ATTENTION: PRITY CLEARY, SENIOR PLANNING OFFICER

**RE: CONCEPT PROPOSAL FOR A RESIDENTIAL FLAT BUILDING WITH
INFILL AFFORDABLE HOUSING, SSD-82899468, PPTIES: 1-5 NELSON
ROAD, LINDFIELD**

ENVELOPE PLAN

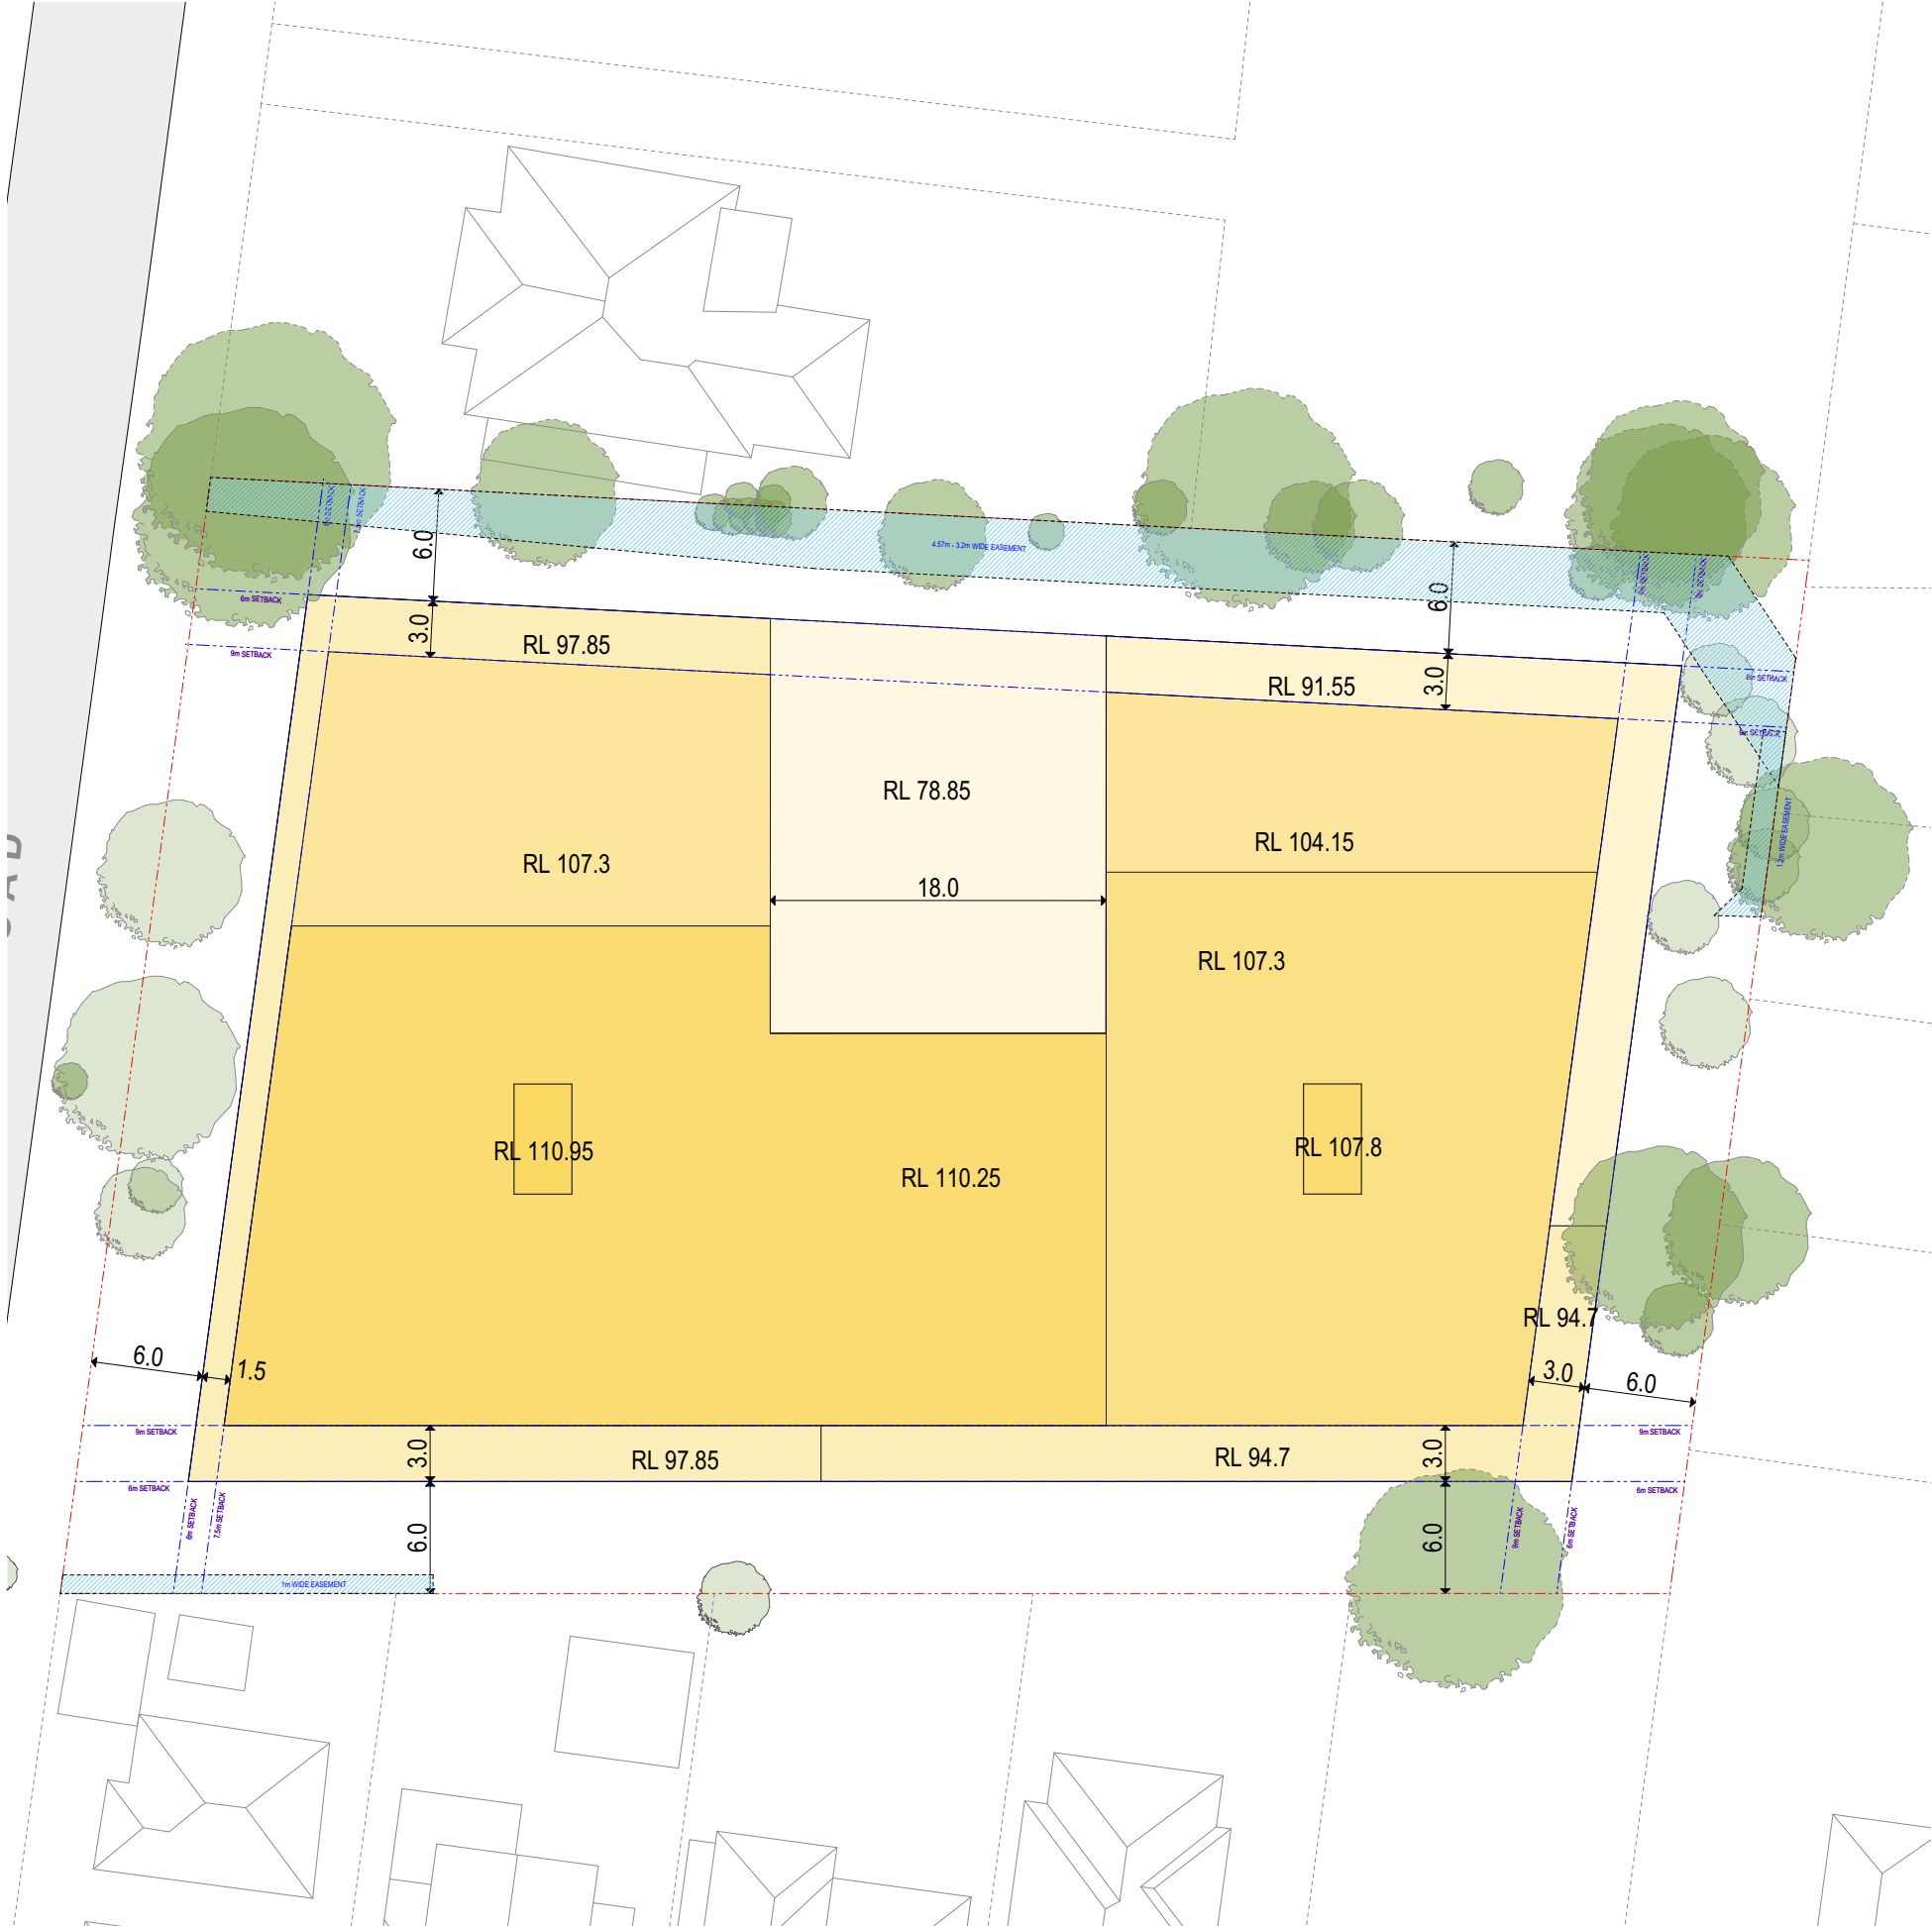
- Despite claims in the EIS that the proposed setbacks comply, the proposed development does not comply with Control 2F entitled *“Building Separation”* under the Apartment Design Guide (ADG) which states that *“at the boundary between a change in zone from an apartment building to a lower density area, increase the building setback from the boundary by 3m”*. Whilst there is not a *“change in zone”*, the proposed development has, in effect, created the same scenario contemplated by Control 2F by having a proposed multi storey residential flat building on the subject site immediately next to a lower density area. Thus, I consider the increased building setback of an additional 3m under the ADG must apply. The proposed development does not comply with Control 2F of the ADG.

- Parts of the proposed carparking spaces at the Basement Level extend within the required side boundary setback, particularly along the southern boundary. This is a further breach which reduces the ability of the southern side setback area to be established with deep soil landscaped area including tree canopy. I also note that the proposed storage/service area referred to above also breaches the Side Setback Control along the southern boundary which also contributes to a diminution in the area of deep soil landscaped area and tree canopy. Thus,

- A further element which decreases the deep soil landscaped area calculation is that of the existing 8.2m-4.578m wide easement which traverses the whole of the northern boundary and part of the northeastern corner. An assessment has not been made as to whether landscaping, including tree canopy, can be established within this easement.

NORTH ELEVATION

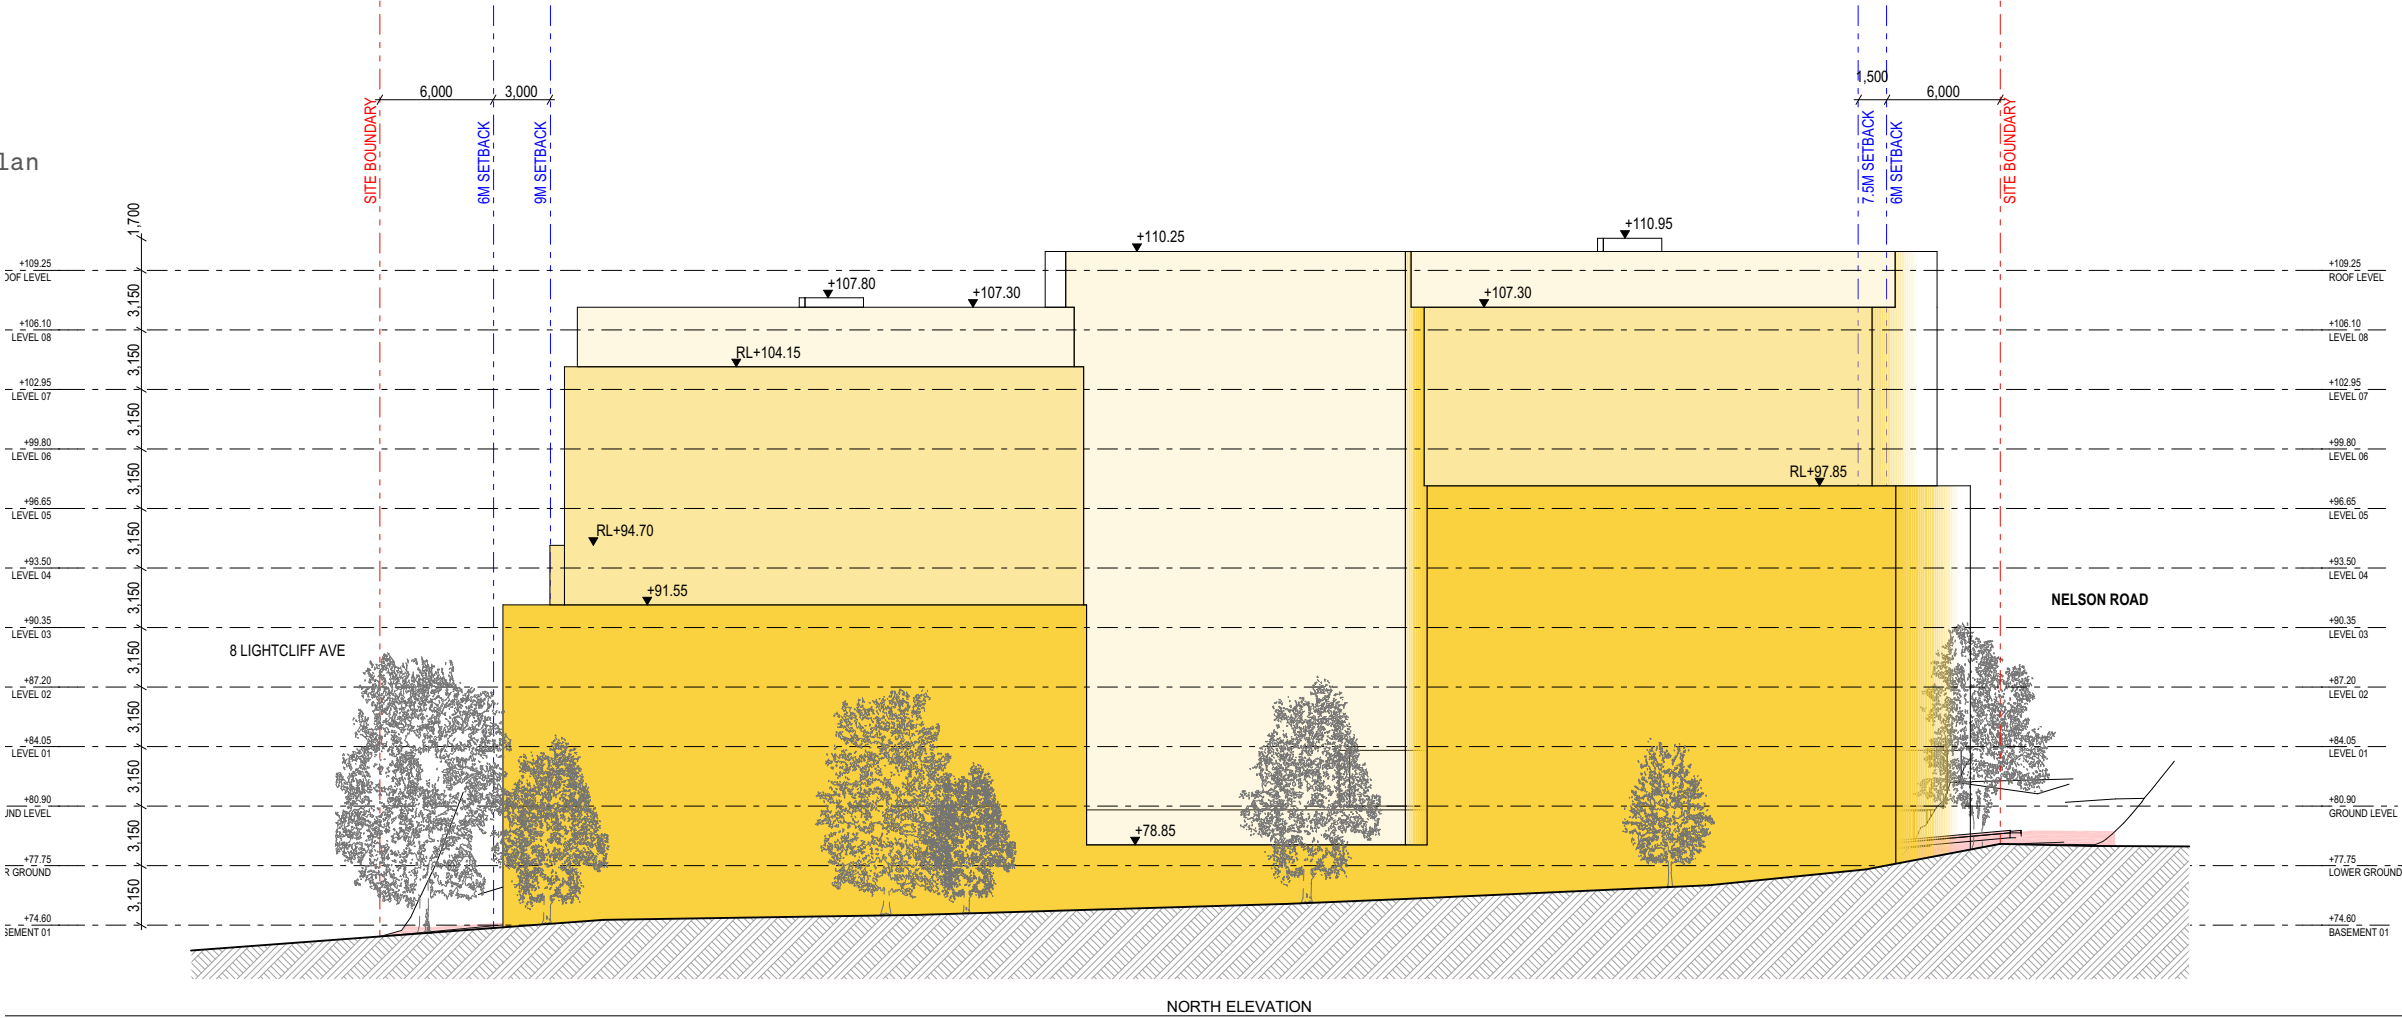
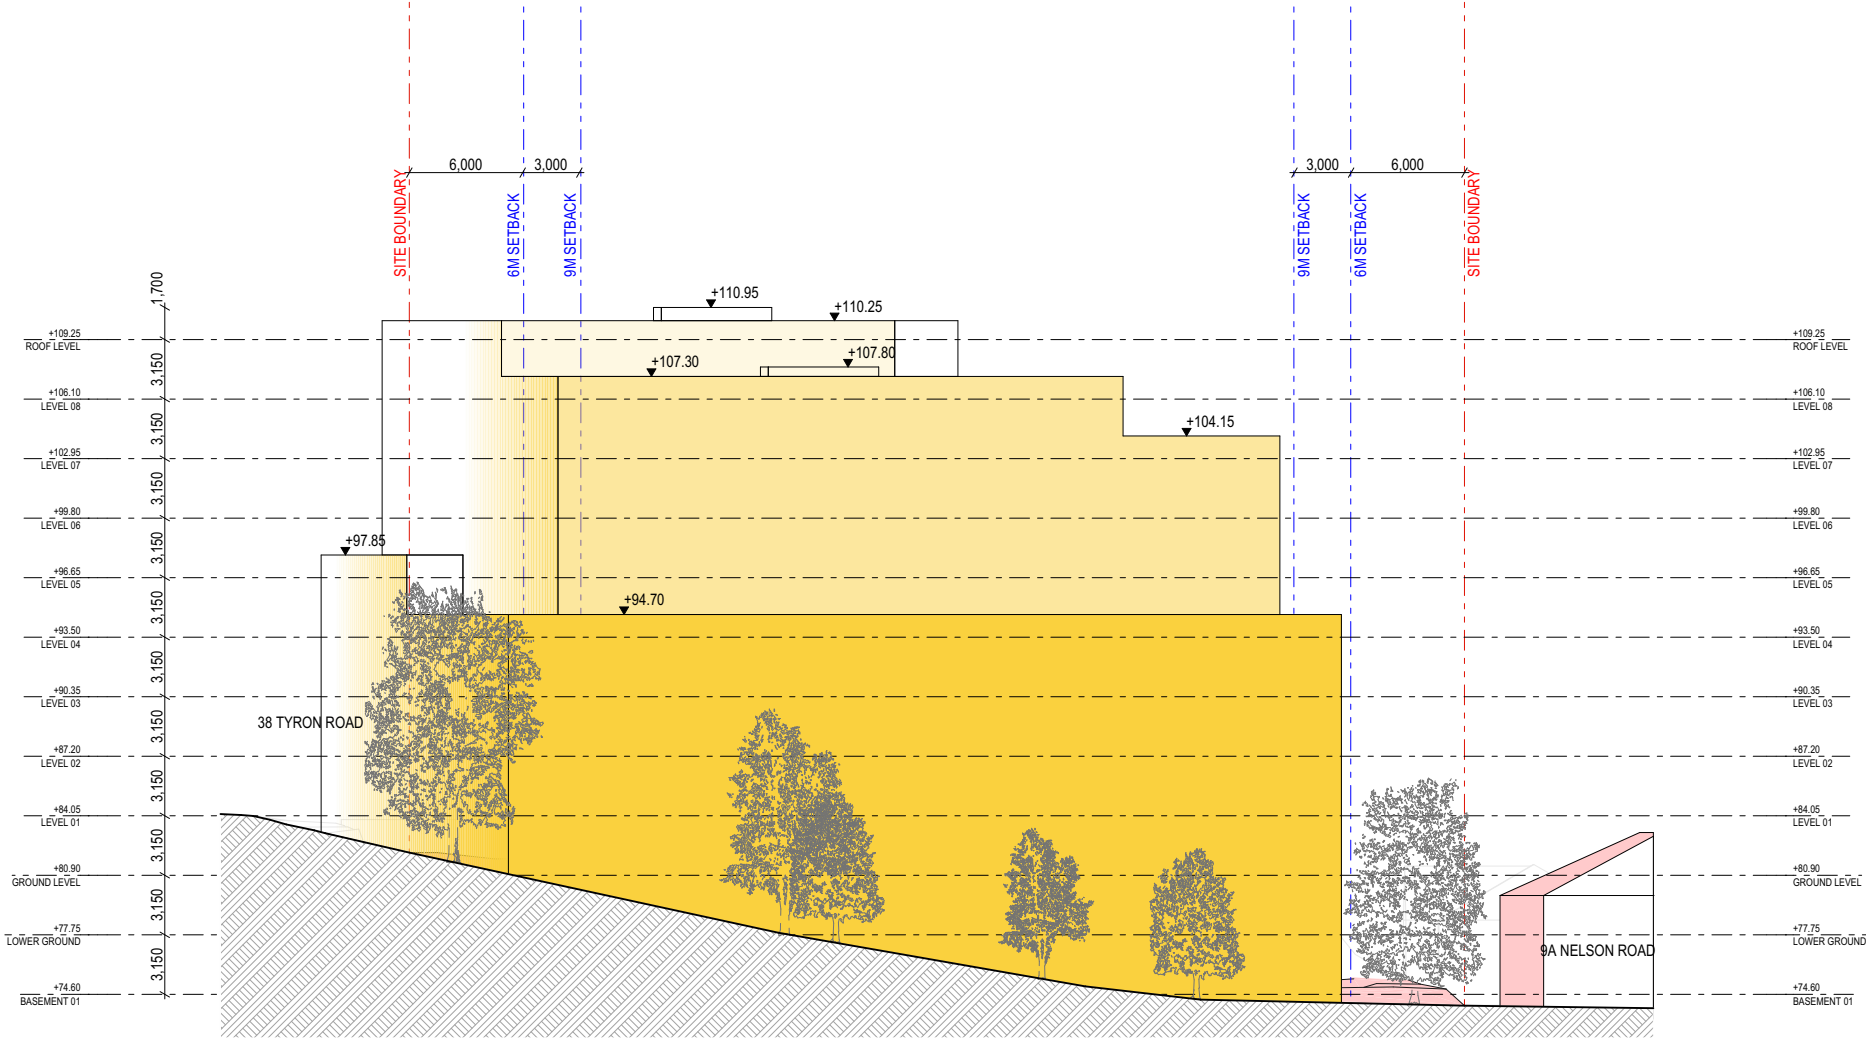
- The proposed development breaches the Height of Buildings Standard, particularly on the proposed northern facade which adjoins low density residential development. For the reasons referred to in this submission, I consider that the Clause 4.6 Request is not well founded and should not be supported.

- Due to the fact that there is low density residential development in the locality, I consider that the proposed facades are required to have a sensitive interface with the neighbouring dwellings. The need for sensitive interfaces is particularly important due to the fact that the properties in the locality are within a Heritage Conservation Area and comprise a number of Heritage Items. I consider that the proposed facades exhibit an insensitive response for the reasons referred to in this submission.
